Contract Residential Development Shanganagh Castle, Shankill, Co

Subject Stormwater Audit - Stage 1 Report

JBA Consulting Stormwater Audit			
Project:	Residential Development at Shanganagh Castle, Shankill, Co Dublin		
Date:	27/11/2019		
JBA Reviewers	Leanne Leonard - Engineer

Stage: PLANNING
Scale @ A1: 1:500
Technician Check: P.J. Mulcahy
Engineer Check: Mark Richardson
Approved: Leonard Brennan
Drawing No: 182-134-001
Rev: PL0

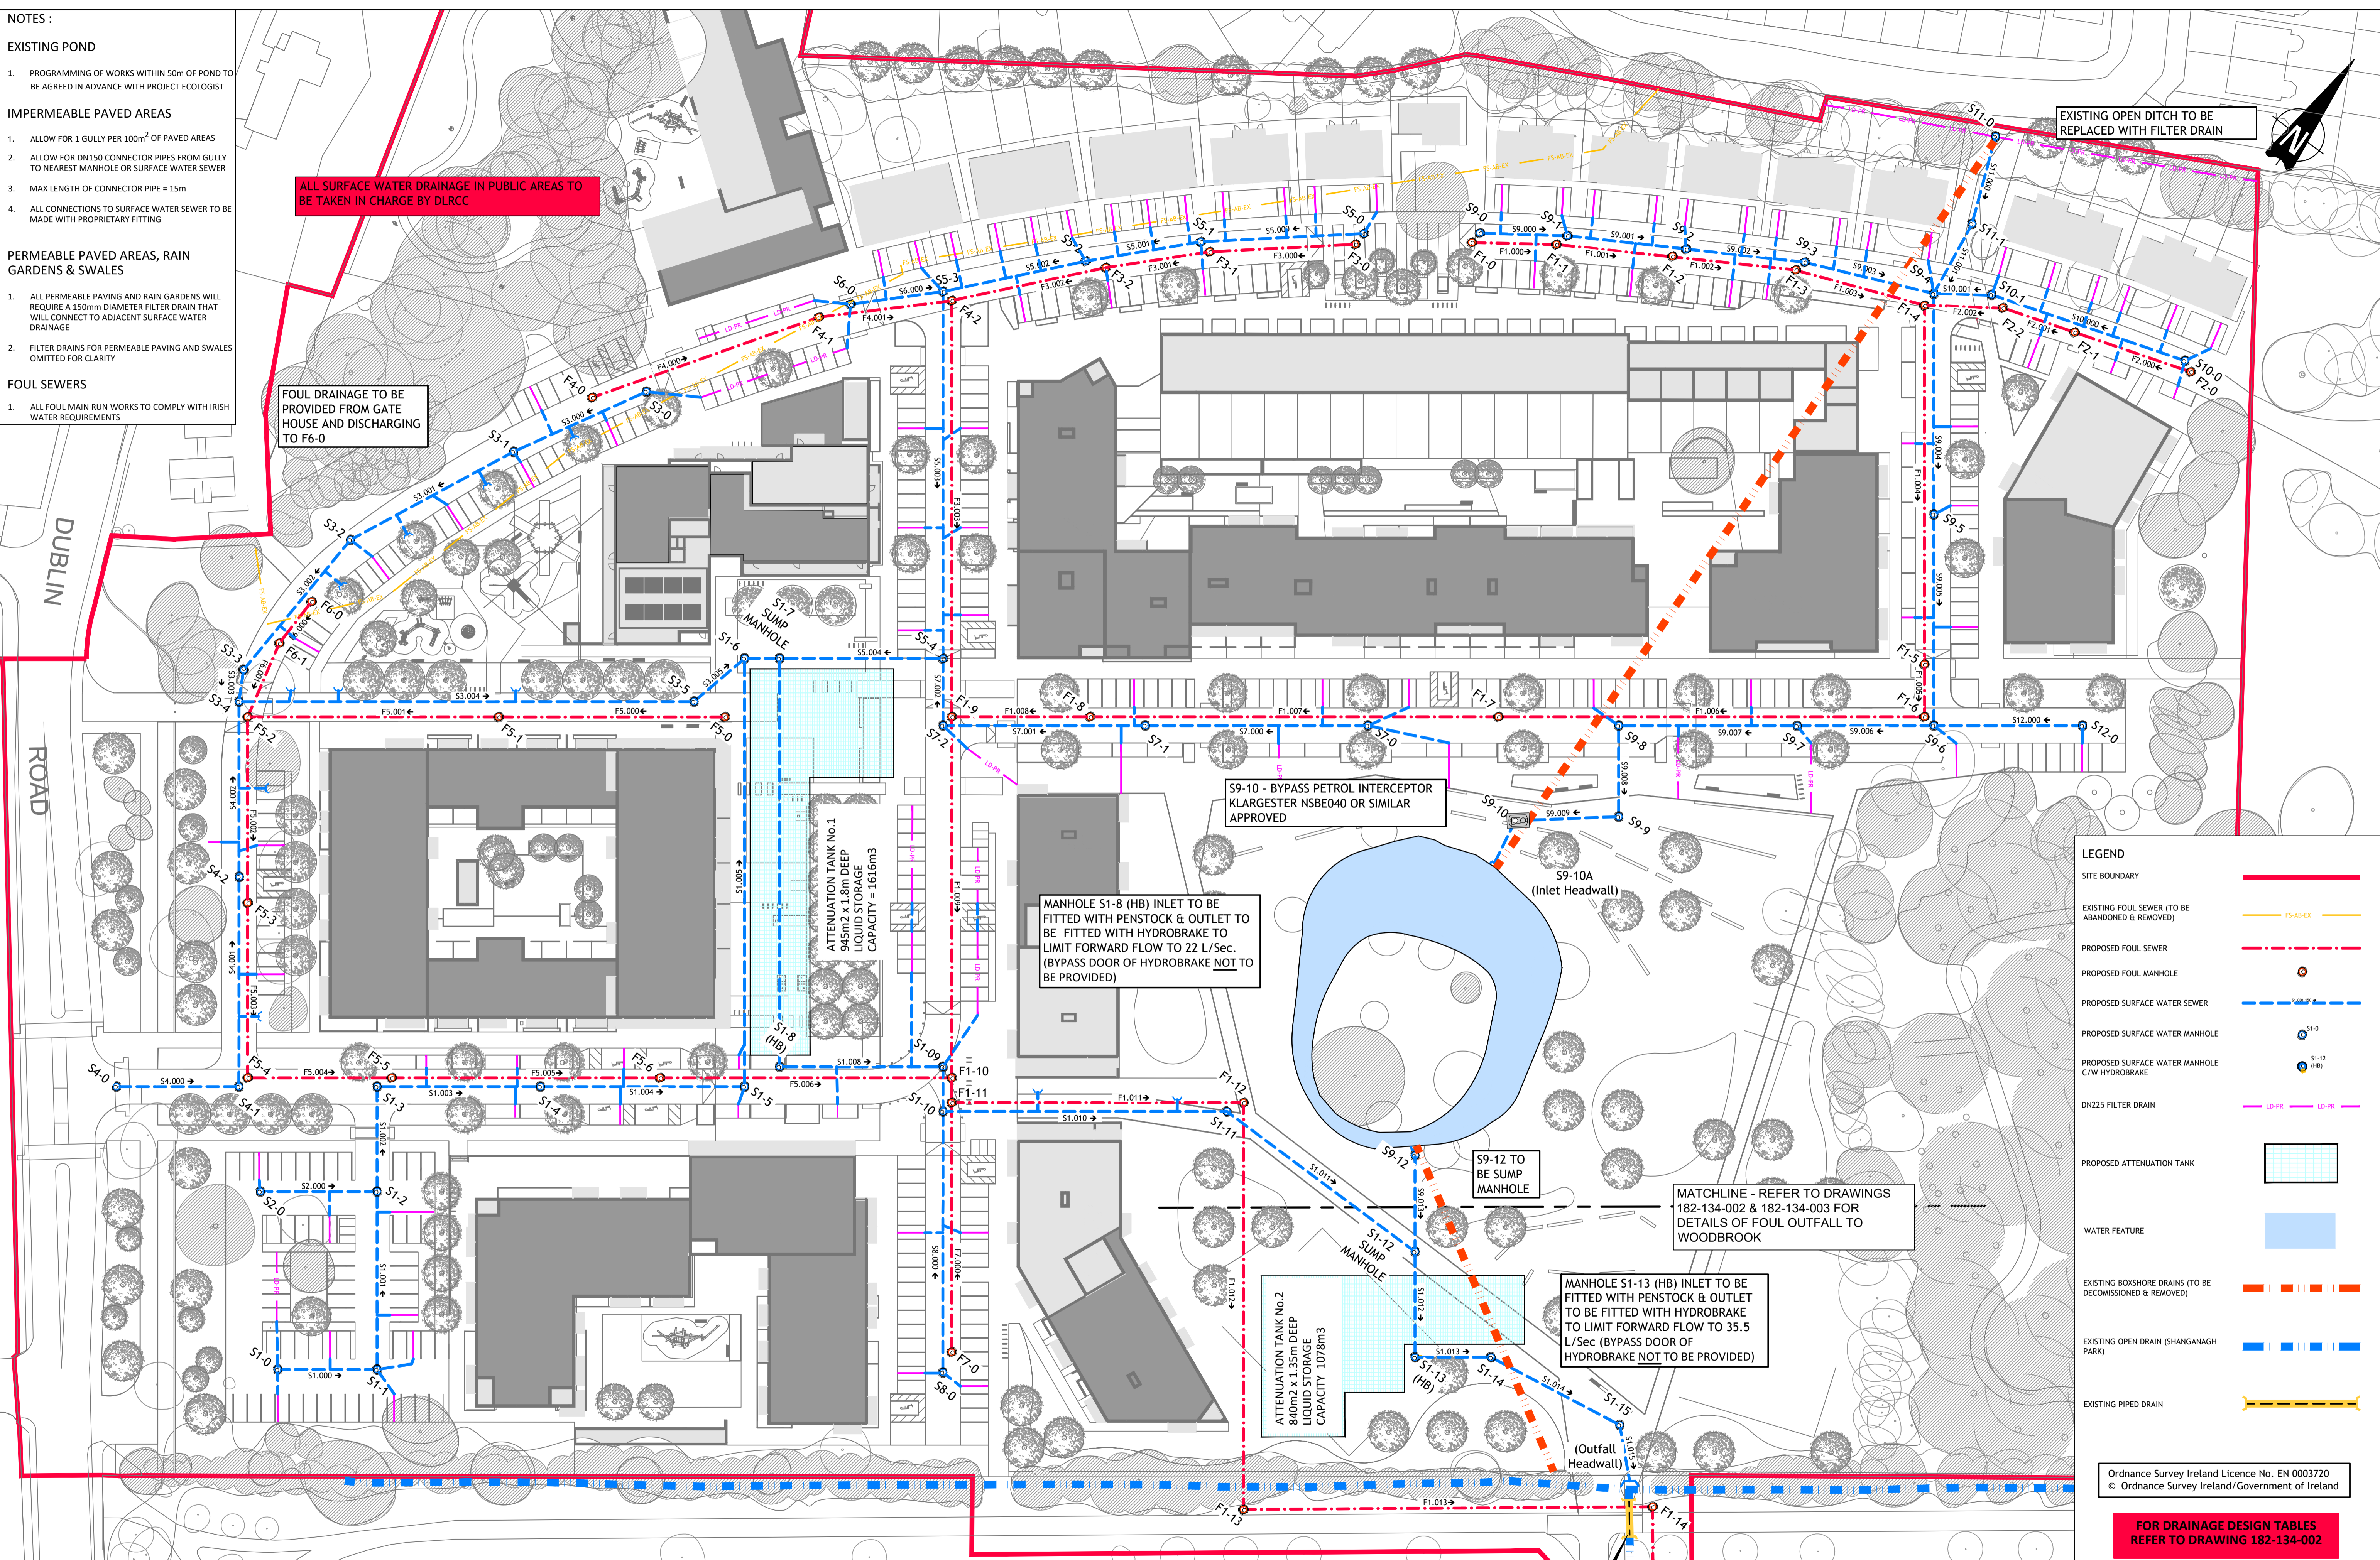
Item No.	JBA Review Comment	Comment/Clarification Request/Suggested Mitigation	Response from Client/Client Representative	Acceptable / Not Acceptable
8	Routing of Existing Filter Drain to Northern Boundary The routing of the existing filter drain from the northern boundary appears to traverse the underside of a semi detached house. The routing should be revised such that same is accommodated through the proposed 'pedestrian cut through' area immediately east and as referenced on the AECOM landscape drawing	Punch to review and advise.	There was a discrepancy between the architects and landscape architects layouts. The proposed route was chosen as this was shown as a green area. The sewer will be routed clear of proposed buildings.	Acceptable
9	Pipe Run S1.000  Not clear what the purpose of pipe run S1.000 is and if sufficient space exists given requirement for division wall between both properties.	Punch to review and advise.	Noted, Pipe S1.000 will be removed.	Acceptable

10	Pipe Run S1.008 With flow being throttled at manhole S1-8, the pass forward flow is 22l/sec. It is noted that the downstream storm sewer is 600mm diameter which is considered too large for the said flows and associated velocity of flow	Punch to review and advise.	The diameter of the drainage downstream of hydrobrake flow controls will be re-sized to suit the proposed discharge rate.	Acceptable
11	SuDS Strategy Given the existing pond is being used to drain part of the subject site, was any consideration given to utilising it to provide the required attenuation volume in lieu of underground tanks which would enhance water quality further?	Punch to review and advise.	Consideration was given to using the existing pond for storage. However the pond is relatively shallow. Additionally the pond was observed to be heavily silted and as such undergound tanks were chosen to provide storage. The primary reason for routing through the pond was to maintain water level in the pond as the pond is of ecological value. It is intended for the pond to be used as a SUDS measure to provide a measure of surface water treatment and continued amenity feature, but not attenuation.	Acceptable

Stage: PLANNING
 Scale @ A1: 1:500
 Technician Check: P.J. Mulcahy
 Engineer Check: Damien Egan
 Approved: Julie Tierman
 Drawing No: 182-134-004
 Rev: PL0

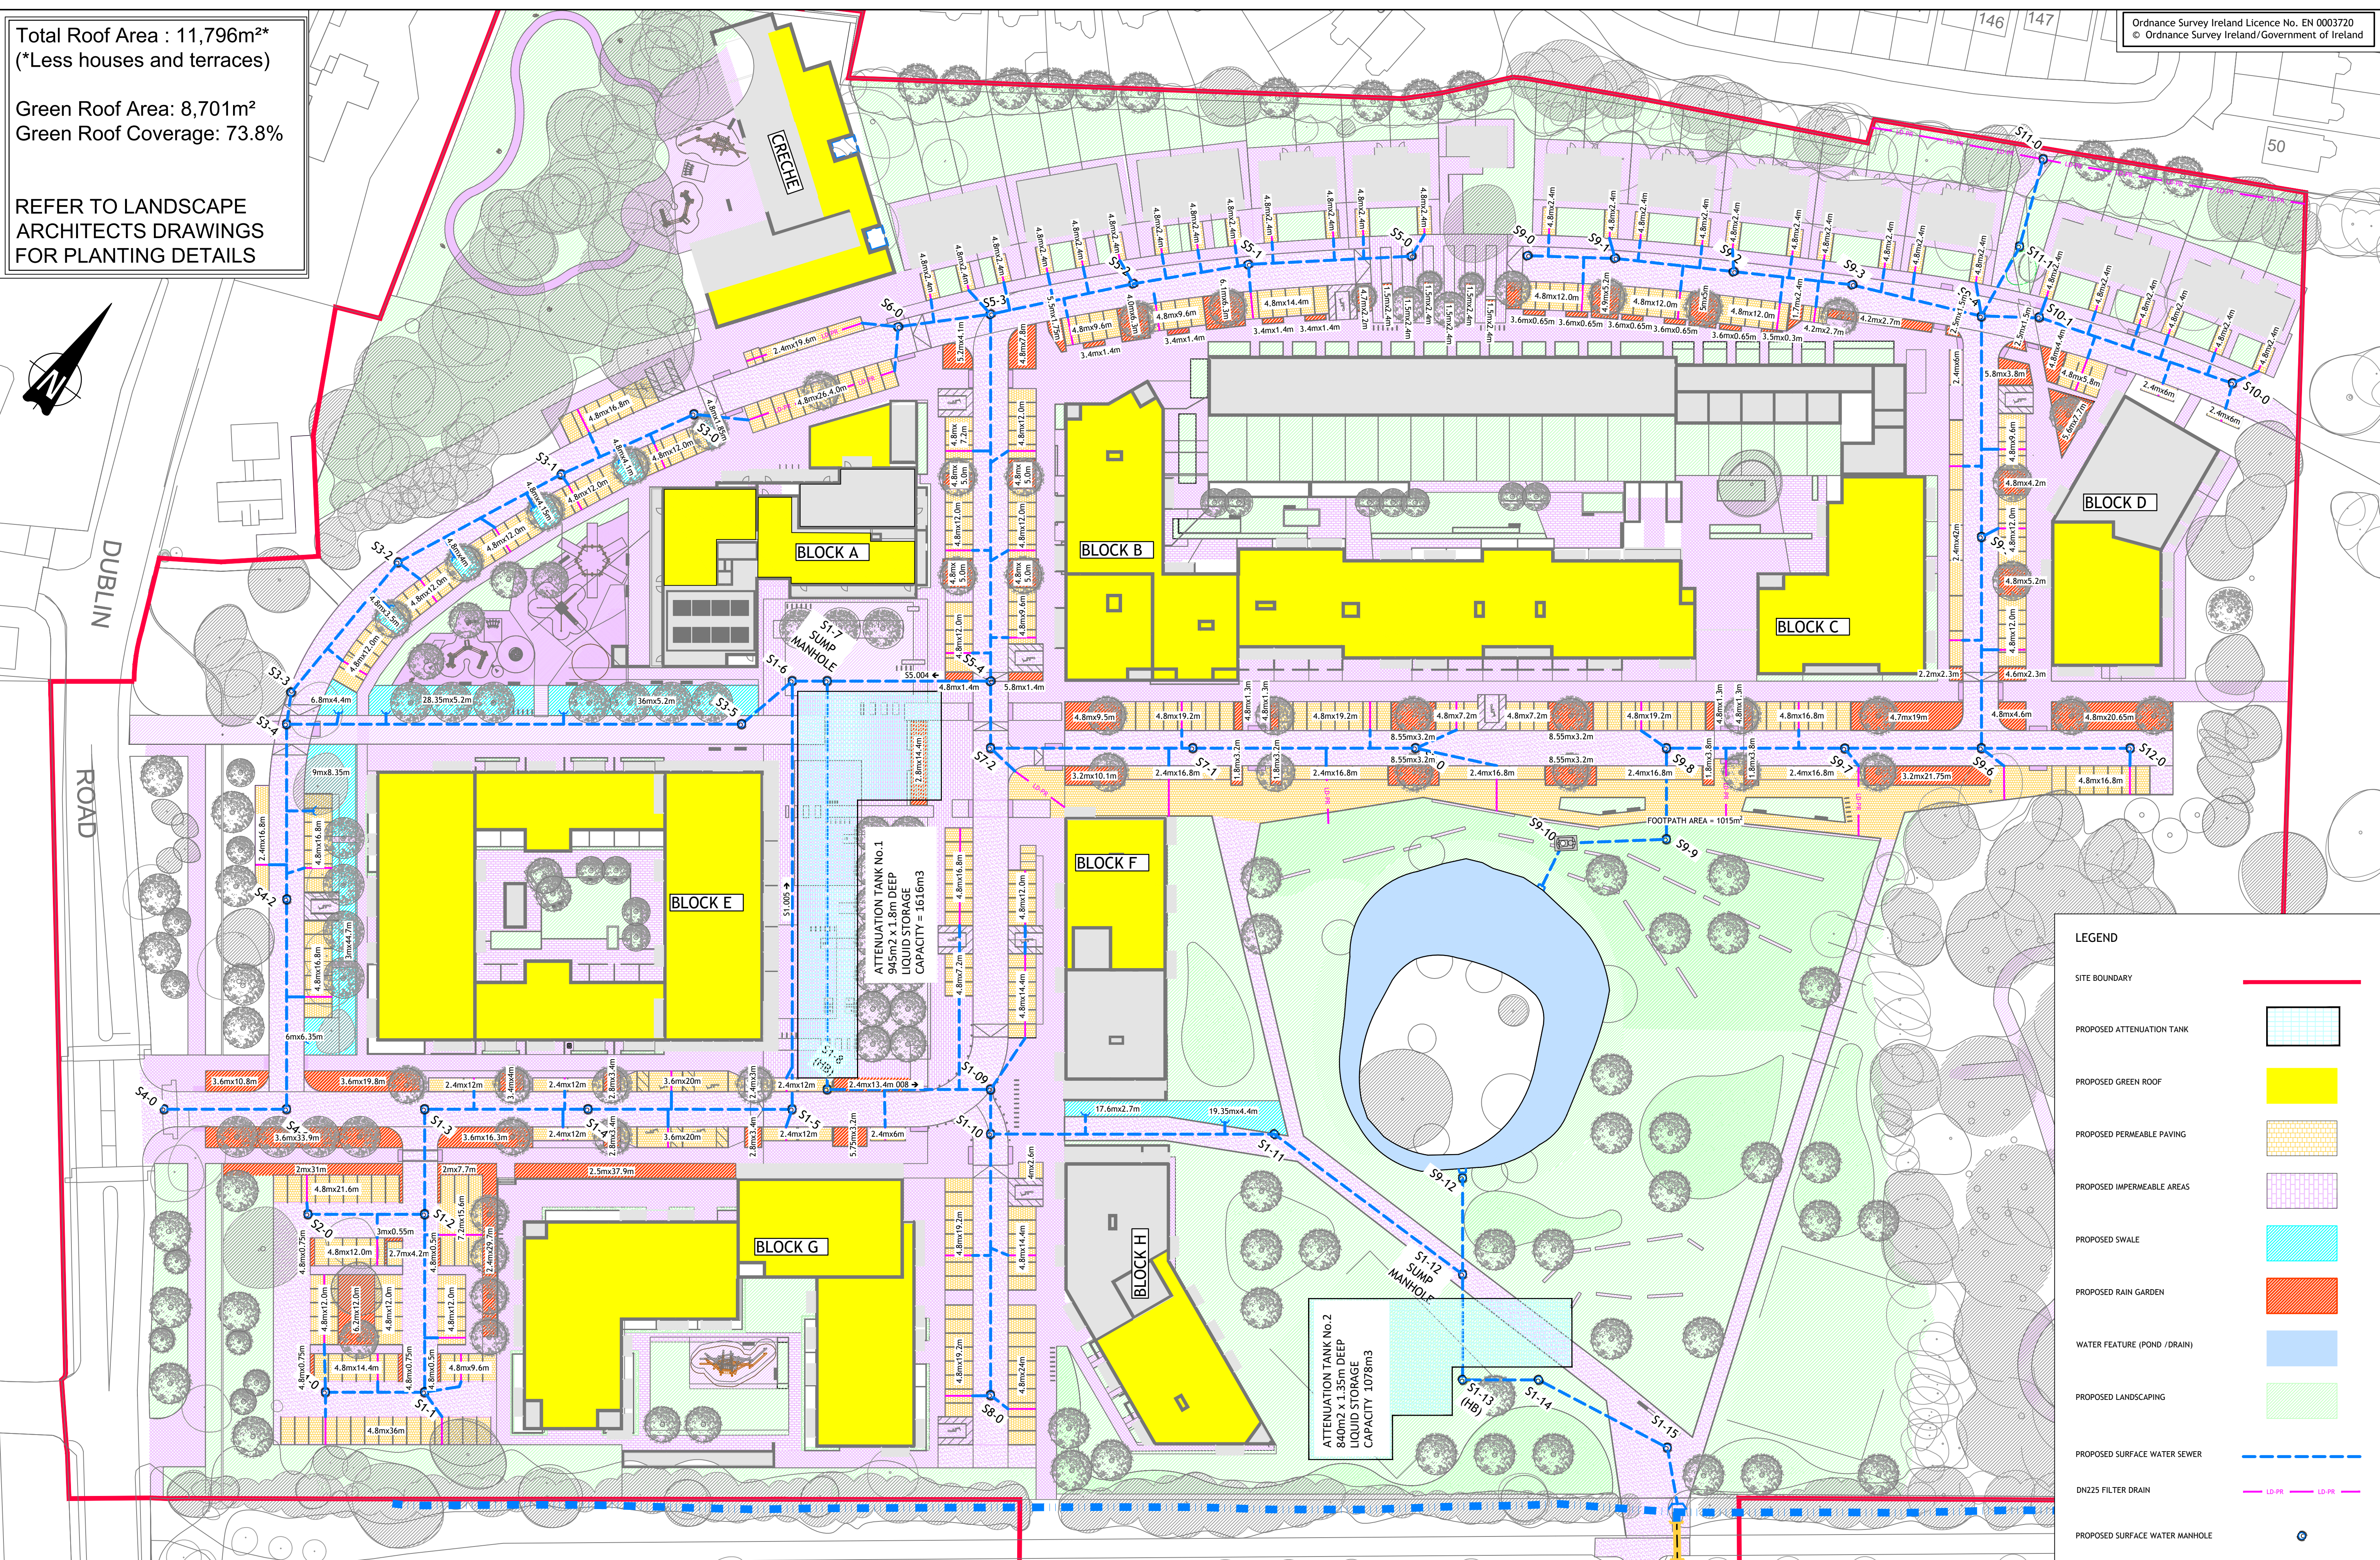
6	Interception Interception measures provided for most surfaces throughout the site with exception of some internal access roads. As no infiltration is deemed available throughout the site (from the site investigation) and given the limitations of Table 24.6 of the CIRIA SuDS Manual, interception of roads are to be addressed.		Interception of runoff from roads and other hard pavement is to be provided via one of the following, subject to the specific location on site: runoff to lined pervious pavement; runoff to unlined tree pits, runoff to unlined swales; runoff drainage to existing pond. In all cases (except the pond), treatment volume will be provided by the voids within the proposed filter media (pavement buildup, tree soil or swale topsoil), and an appropriate thickness of media will be provided to suit the drained area. Note that some roofs are also intended to drain to the pond. A final calculation and explanation of all areas will be included in the final planning submission.	Acceptable

12	Other SuDS Considerations  For the apartment buildings, it is possible to provide rainwater harvesting for the flushing of toilets etc thereby reducing the volume of stormwater being discharged downstream.	Punch to review and advise.	Rainwater harvesting was considered for the the development. However the client has a preference for green roofs. Hence green roofs have been favoured over rainwater harvesting throughout the development.	Acceptable
13	Other SuDS Considerations Tree pits are considered viable for interception of select isolated roads and parking areas with no current treatment mechanism	Punch to review and advise.	Tree pits are to be included as part of the proposed rain gardens. Rain gardens have been provided throughout the site where practical.	Acceptable
14	Green Roof Details  For the green roofs as shown on drawing nr 182-134-004, no cross-sectional details are available	Punch to review and advise.	The architect is to provide the proposed extensive green roof cross sectional details as part of planning pack.	Acceptable

ATTENUATION TANK No.2 - PLAN
SCALE 1:250

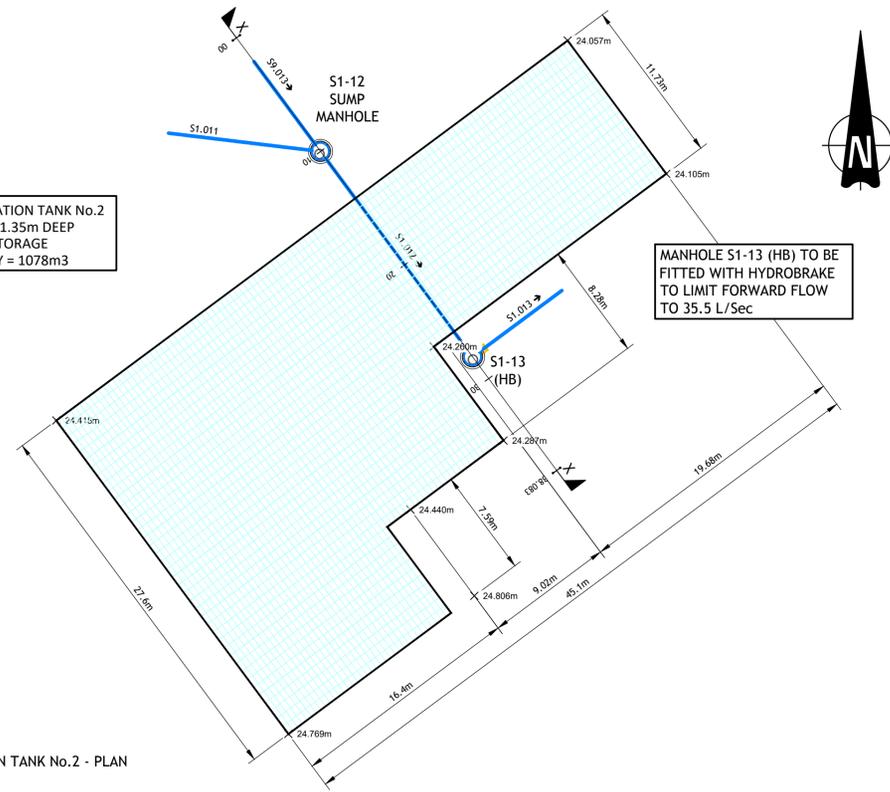
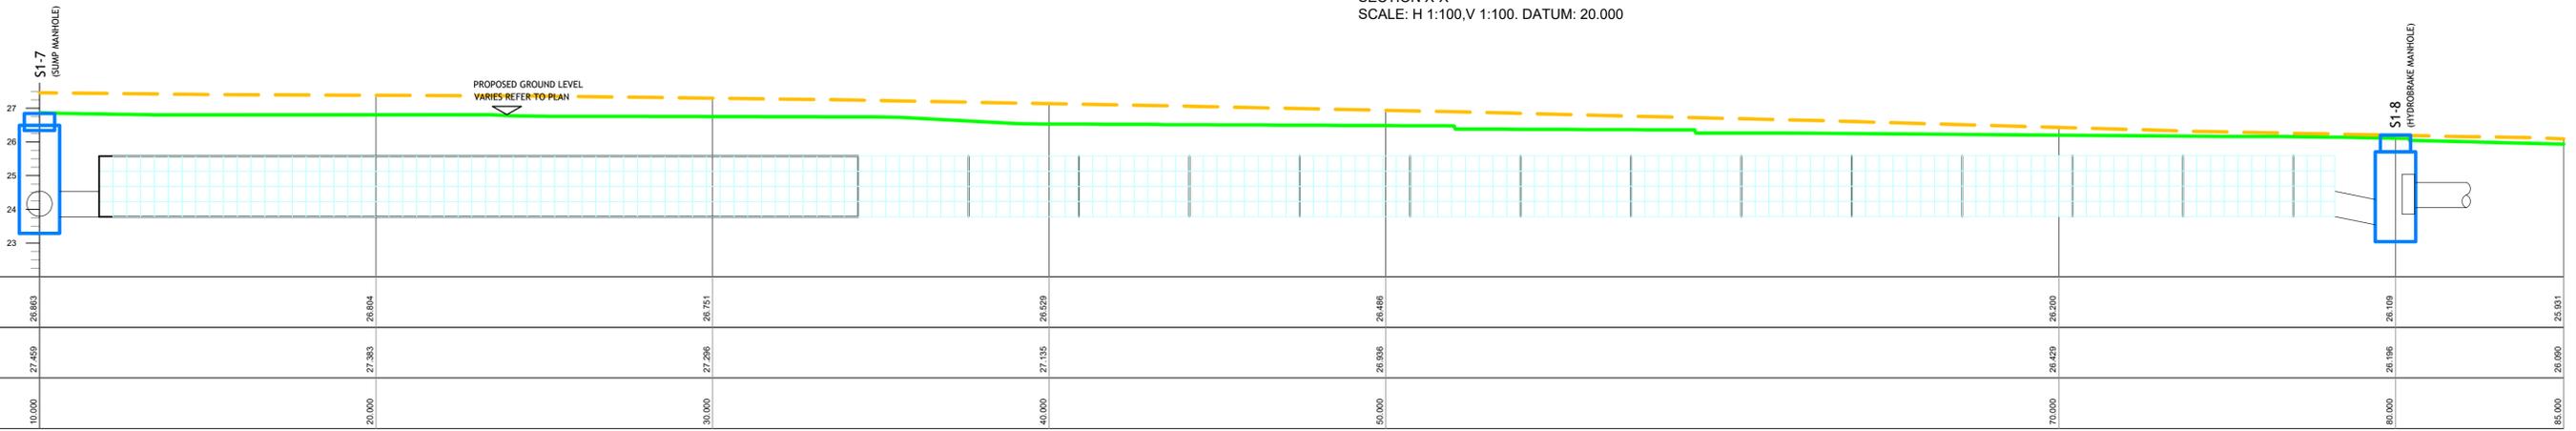
(Table 3.3) assuming effective pre- er of treatment train components are
		No. of treatment train components recommended	Comment/Proposals
	Roof areas	1	Green roof for all apartment blocks and crèche
	Residential roads, parking areas, commercial zones	2	Pervious pavements, tree pits, swales, existing pond.
	Refuse collection, industrial areas, loading bays, lorry parks and highways.	3	Not applicable.
	storm flows prior to Generally, site prop	discharge off-site.	cture is provided for the attenuation of ent train recommendations within the
Climate Change	SUDs Manual.  An allowance of 20% increase in flows has been included for climate change which is greater than the 10% requirement in the GDSDS. This adequately addresses Section 16.12 of the "Development Management – Thresholds Information Document".		
Discharge Rate / Flow Control	Limited to Qbar (37.2l/sec for all rainfall events)		
Volume Storage	Punch have provided calculations for the proposed attenuation volume. 1,701m3 is available in tank #1 with an additional 873m3 provided in tank #2.
